1 b) External Lifts, Stairs & Gantries

Heritage Council Comment 1 b)

DPE Comment

Figure 68: Level 1 Gantry Balconies Pier 2/3

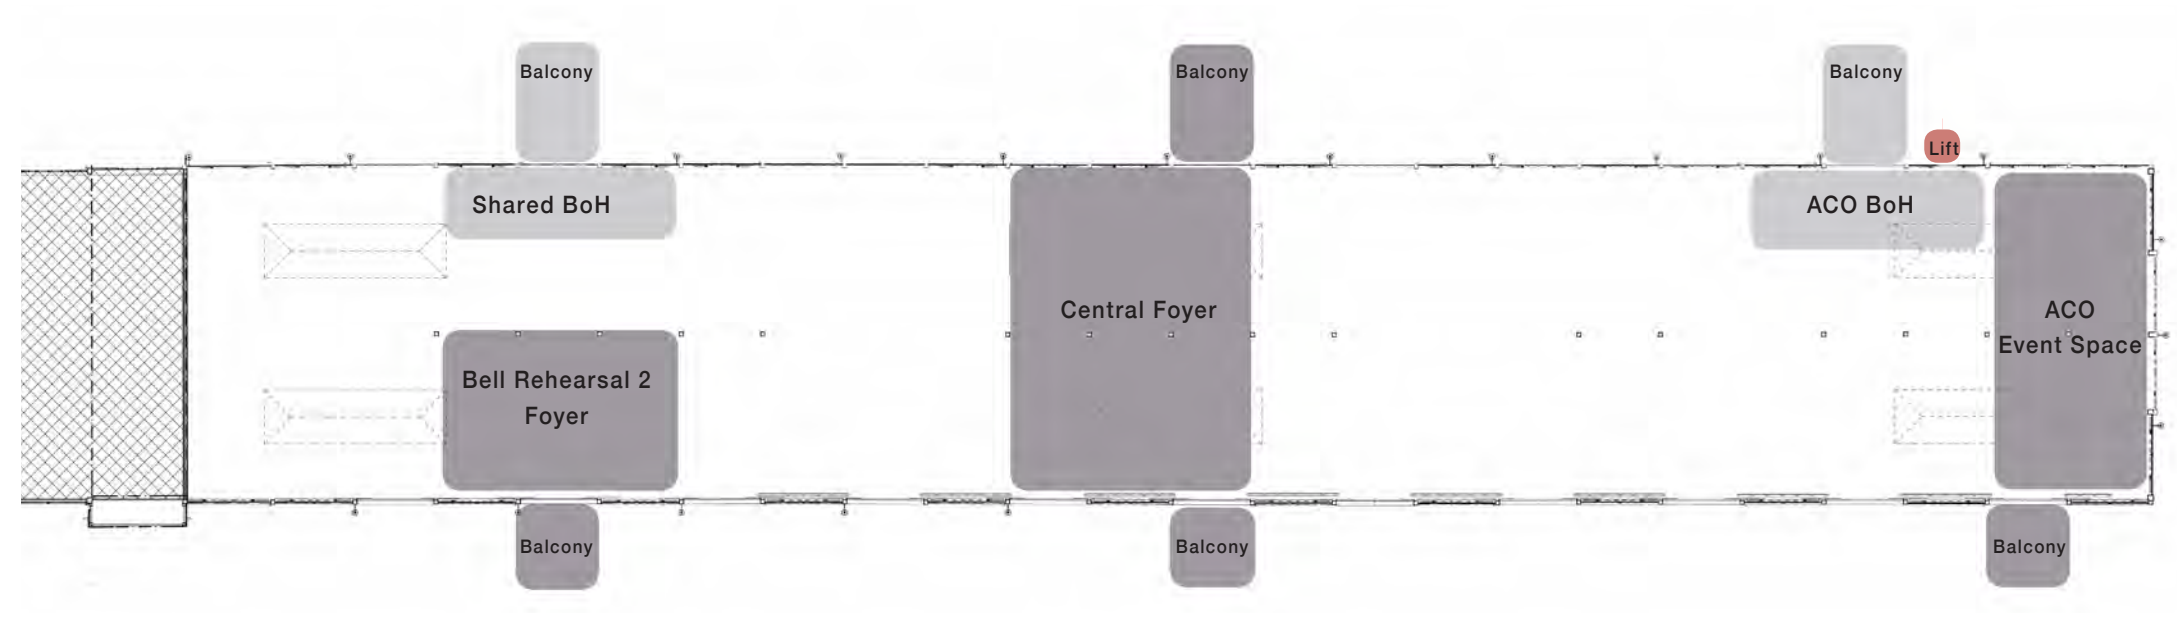
It is understood that the proposed new stairs, lifts and gantries are critical operationally and for accessibility and egress. However limited information has been provided regarding the proposed external additions including stairs and lift shafts at Piers 2/3 and 4/5. A sympathetic and modest design approach must be adopted for all external additions to minimise impacts to the visual prominence and industrial character of the Wharves. The size of lift shafts must be reduced as much as possible to reduce ‘clutter’ on the wharf apron. Further design details for all external additions must be provided to the Heritage Council for assessment prior to approval of this project.

Consideration should be given to reviewing the size and extent of external balconies and lift shafts, and the width (and location) of external stair landings, to ensure the potential impacts of these structures on the heritage character of the wharves and public access around the wharf aprons is minimised as much as reasonably practicable.

Explore opportunities to remove the support stands from the external balconies to reduce potential for visual clutter on the wharf apron and reduce their visual prominence.

The design of the gantry balconies interprets the historic gantries which once travelled along the buildings in terms of size, form and detailing. The original gantries were sized to relate to the structural bays of the wharf buildings and extended to the edge of the wharf apron to provide access between the Upper Shed level and ships in port. The new gantry balconies are sized to reference the original and hence are proposed to be supported on columns located adjacent the wharf edge.
